RE: 2025/92161 - Whitehall Road West, Birkenshaw - Technical approval of oversize manholes

Further to a review of your latest drainage drawing nos 23-341-500-001 rev Q - Drainage Layout, 23-341-500-004 rev C - Drainage Standard Details and 23-341-EXT-002 rev A - External Works and Surface Water Tank, I can confirm that these are now considered to be satisfactory and as such Condition 21 (surface water attenuation) can now be conditionally discharged pending the submission of a suitable "Construction Compliance Certificate" together with "As built" drawing upon the completion of the drainage works.

Title: Surface Water Attenuation Tank
 and External Works

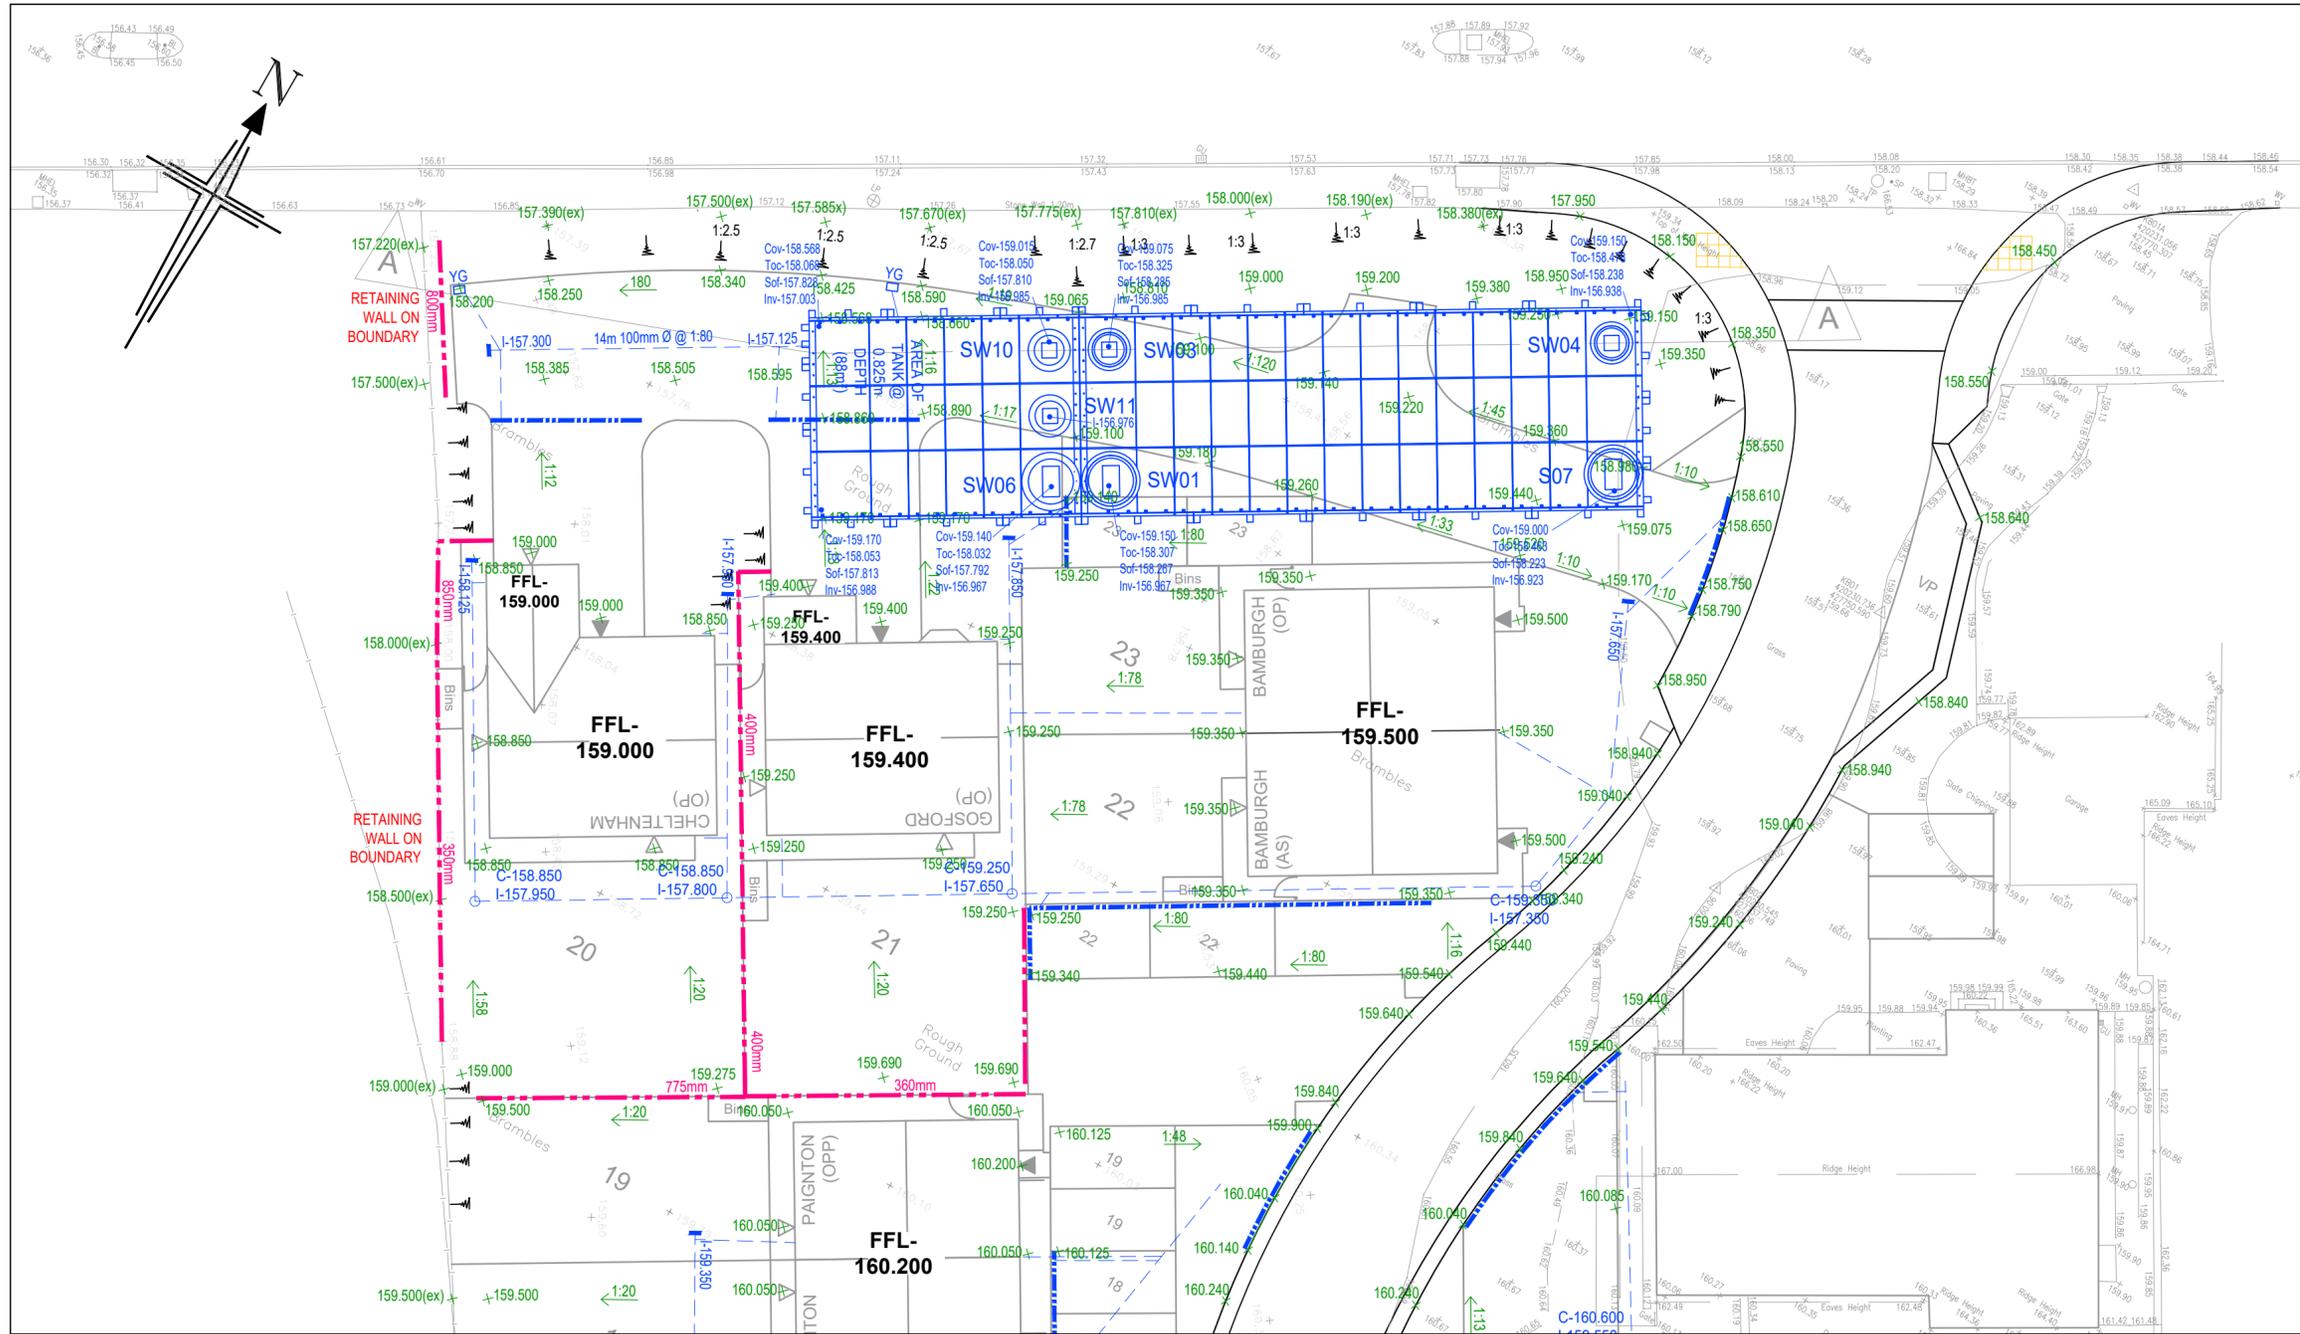
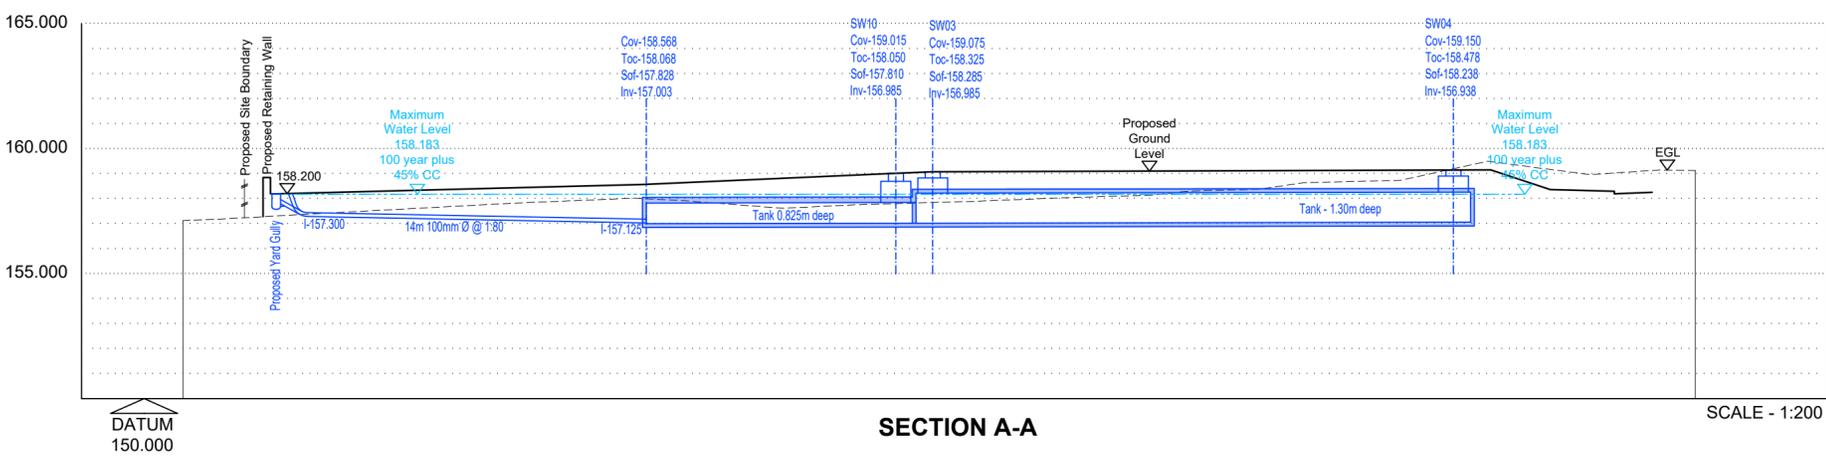
Are you able to provide the necessary dimensioned X-sectional details for the proposed modification to the existing retaining wall abutting your site so as to enable us to advise whether these works will be liable to a formal technical approval?
